**RE: SAGE PLAZA AT 1125 SNOW VISTA BLVD. SW
EROSION AND SEDIMENT CONTROL PLAN
RESPONSE TO COMMENT**

Per the correspondence dated June 22, 2023, please find the following responses addressing the comments listed below:

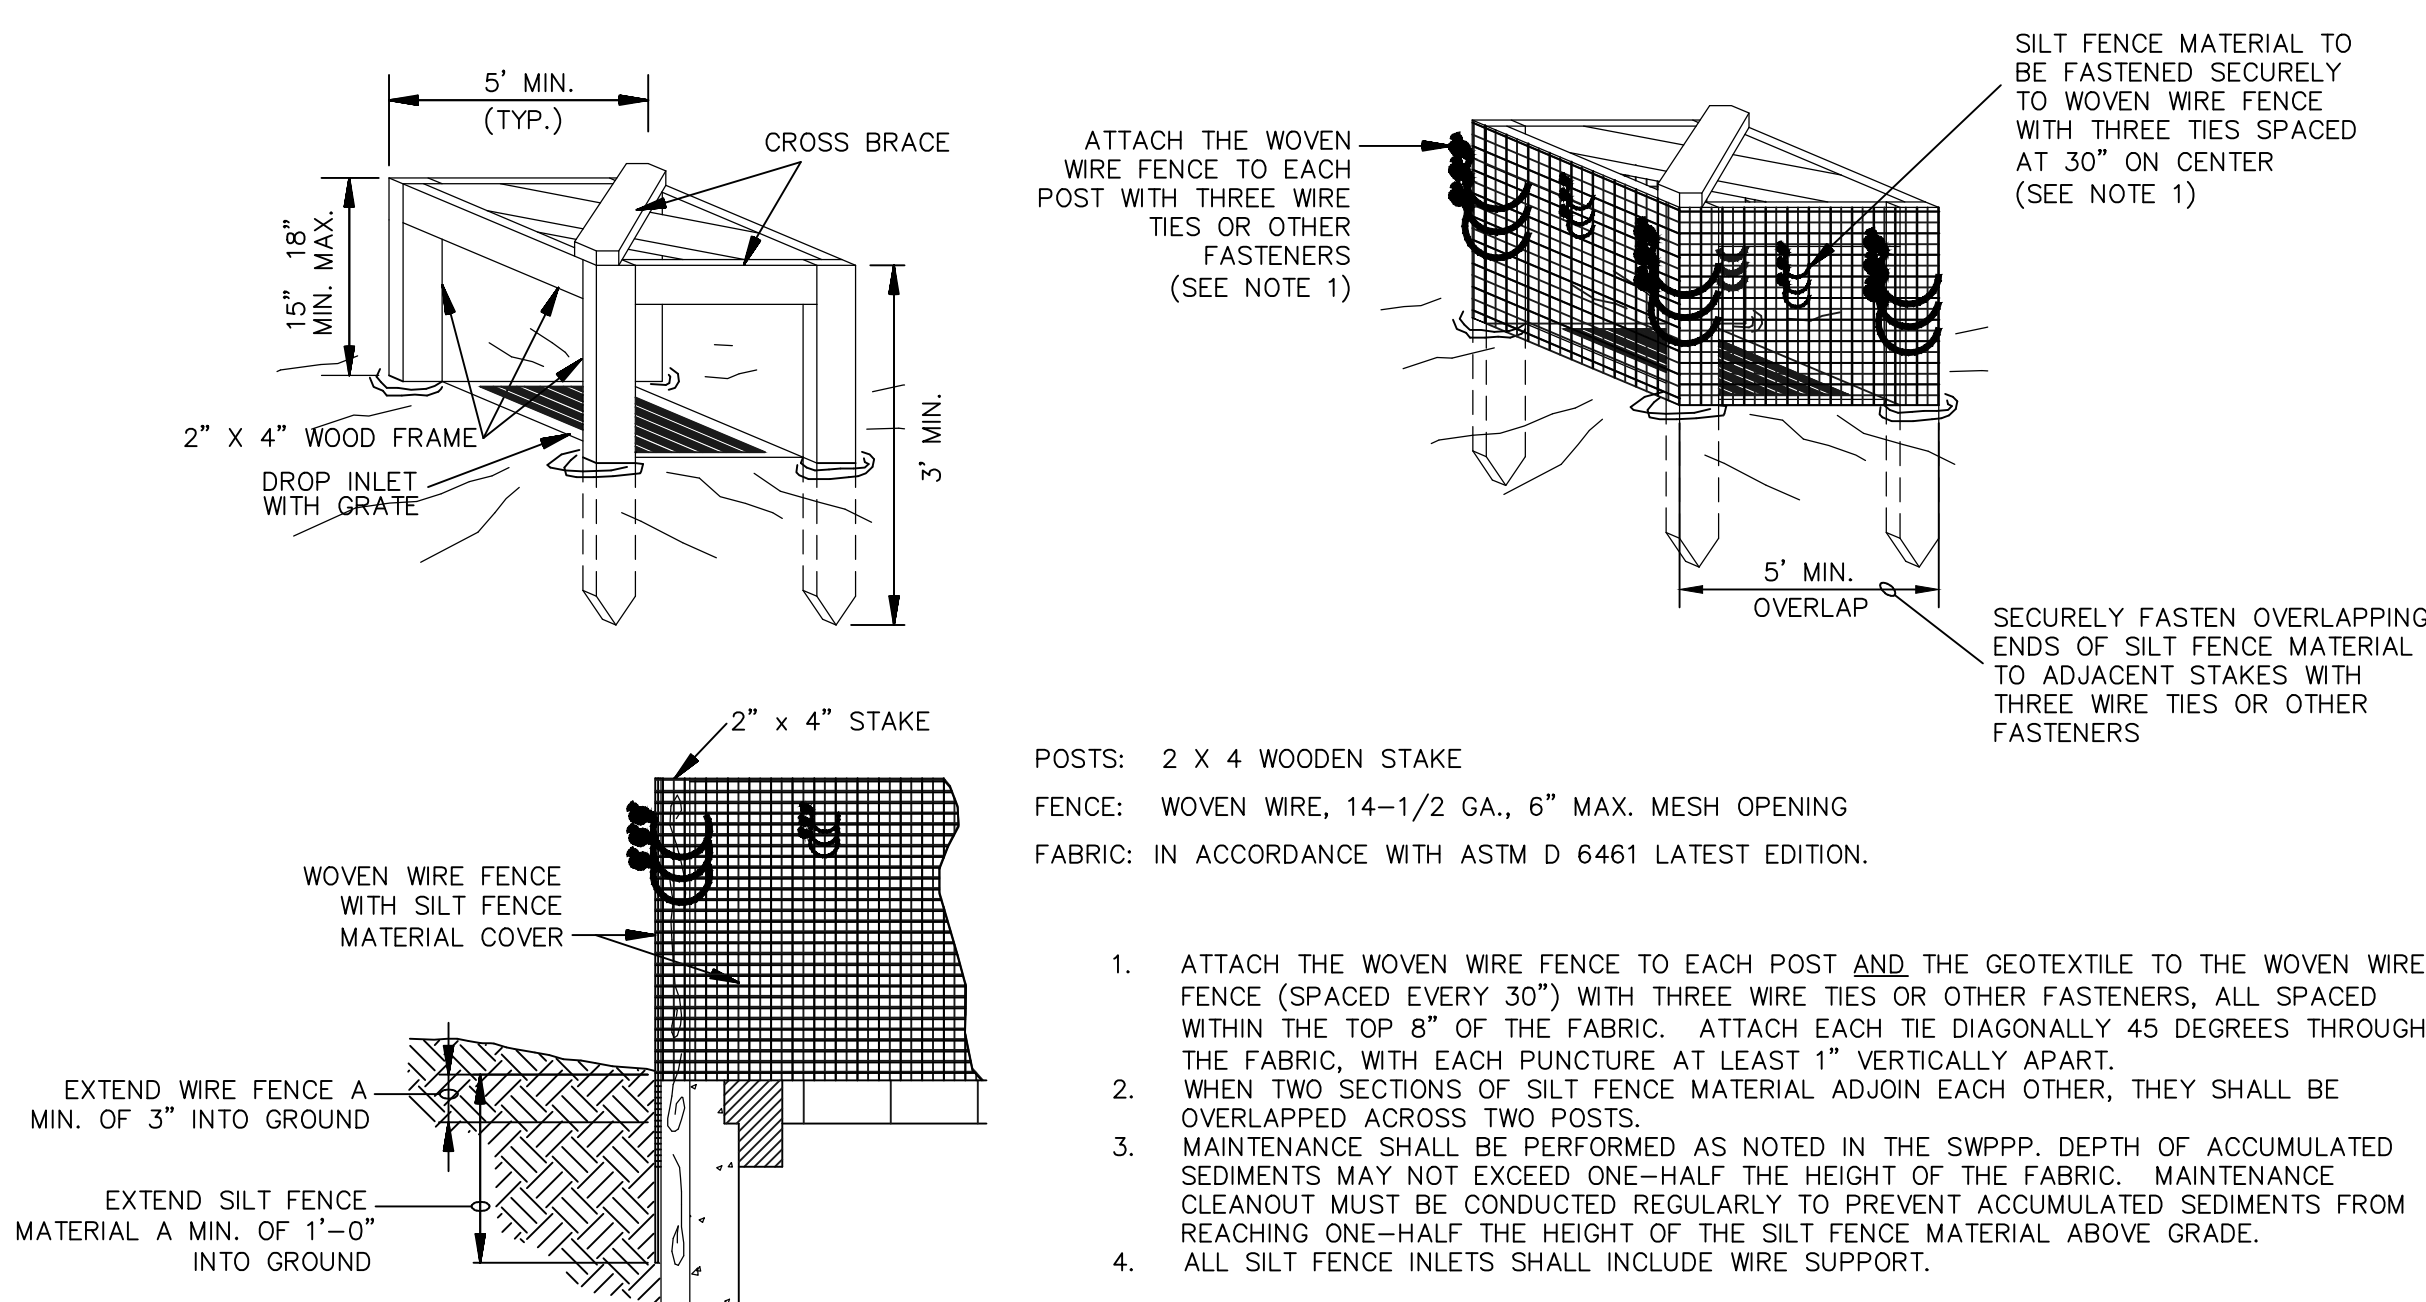
2. The ESC Plan can't be approved until after Hydrology approves the G&D Plan for each specific purpose, Plat, Grading, Building Permit, and Work Order. The only purpose Hydrology has approved so far is Plat, not for construction. The existing and proposed grades must be shown on the ESC Plan, and they must agree with the Grading Plan approved by Hydrology (CGP7.2.4.b.ii)

Response: Attached is the NOI
4. Update the engineer's stamp date each time the plan is changed.
Response: Acknowledged.

Response: Attached is the approved grading plan for grading permit, the current property owner is responsible for the shared private access drive and drainage.
